STATE OF NORTH CAROLINA
DEPARTMENT OF TRANSPORTATION

SUBJECT: Revised permit application for U-3110 B for the SR 1311 (Cook Rd) Widening & Extension from SR 1909 (Westbrook Ave) to SR 1503 (Manning Ave) on NC 100 in Alamance County. Federal Aid Project Number STP-0701(7), Division 7, T.I.P No. U-3110B.

PROJECT REFERENCE NO. U-310B	SHEET NO. 9
R/W SHEET NO.	
ROADWAY DESIGN ENGINEER	HYDRAULICS ENGINEER
PRELIMINARY PLANS DO NOT USE FOR CONSTRUCTION

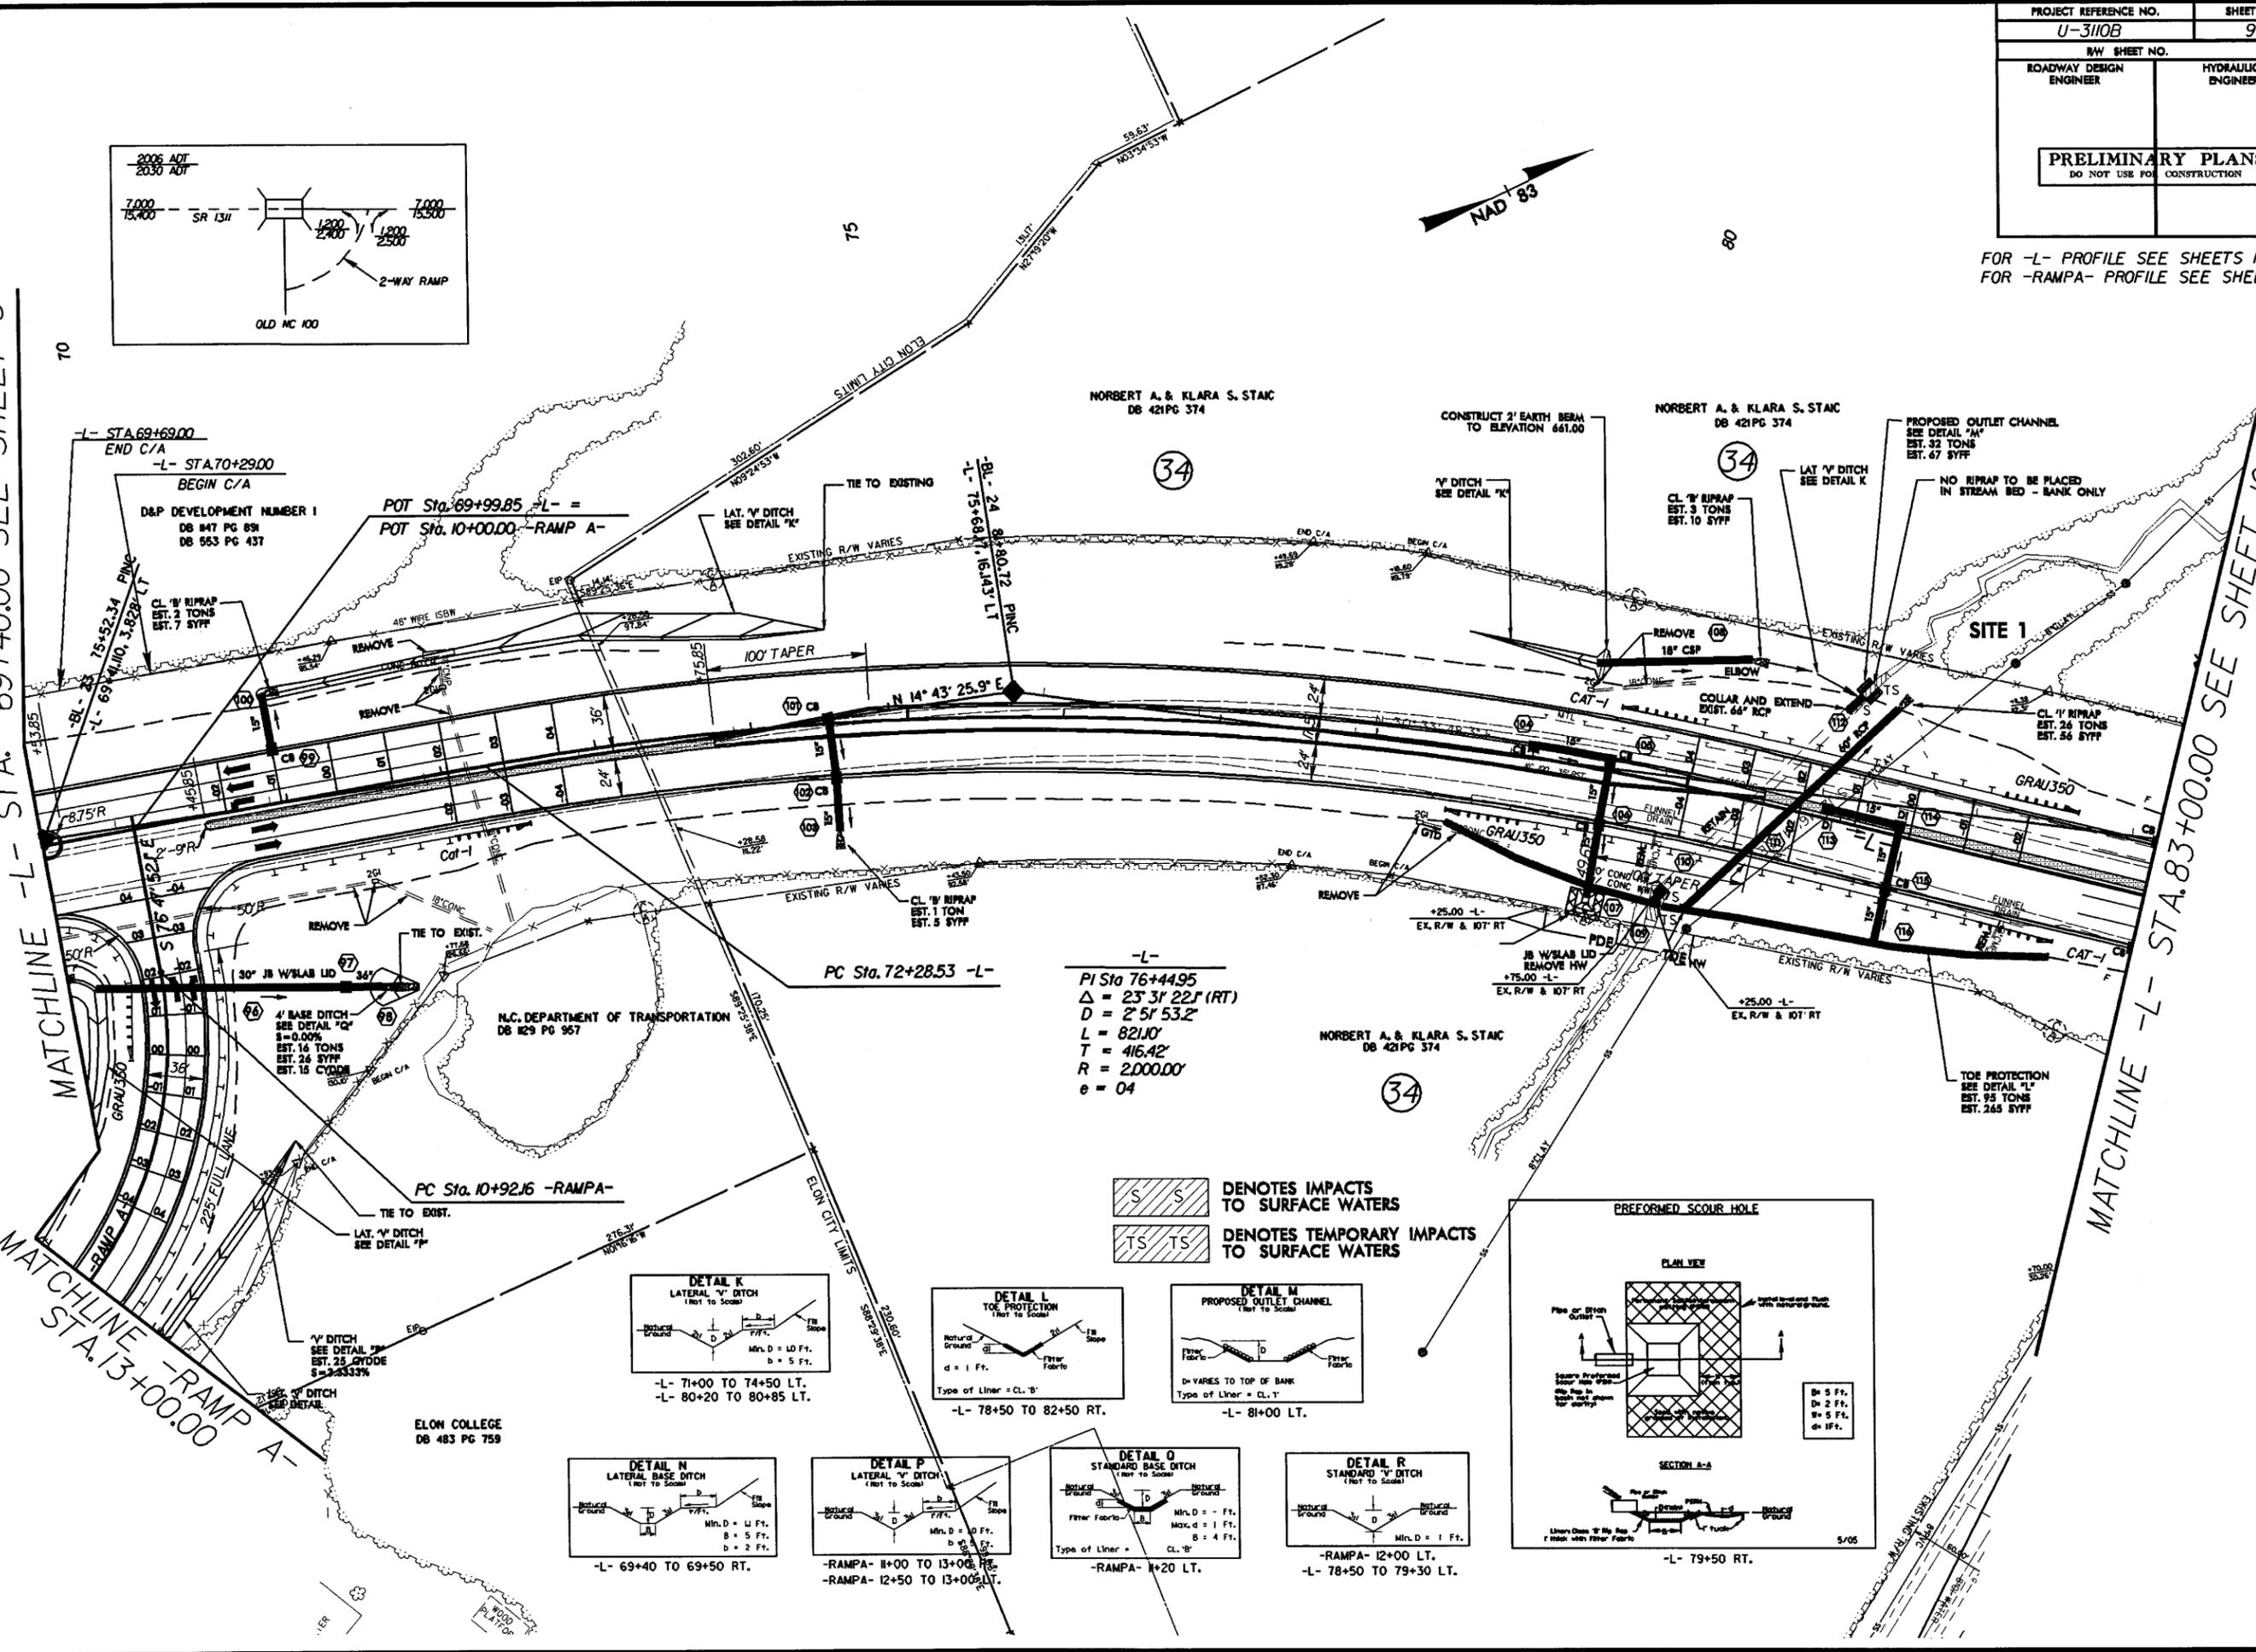
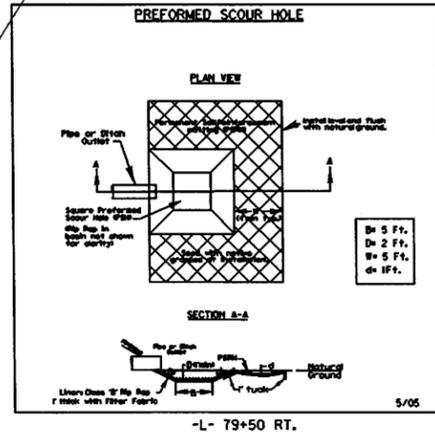
The permit application for U-3110 B was sent out on March 1, 2010. As of May 28, 2010, we have received the Section 404 permit and are awaiting the Section 401 permit. After the application was sent and during the review process by NC Division of Water Quality, there was a request for a slight change to be made to the drainage on the southeast side of NC 100 at Site 1. This revision reduced the number of outfalls and combined two drainage systems. The revision results in a better design to minimize impacts to water quality. There are no additional impacts due to this design change. Only the type of impact changed; 0.001 acres of impact changed from mechanized clearing to excavation. Therefore, no modification to the Section 404 permit is requested. Please replace permit sheets 2 of 7, 3 of 7, and 7 of 7 and plan sheet 9 with the revised sheets enclosed.
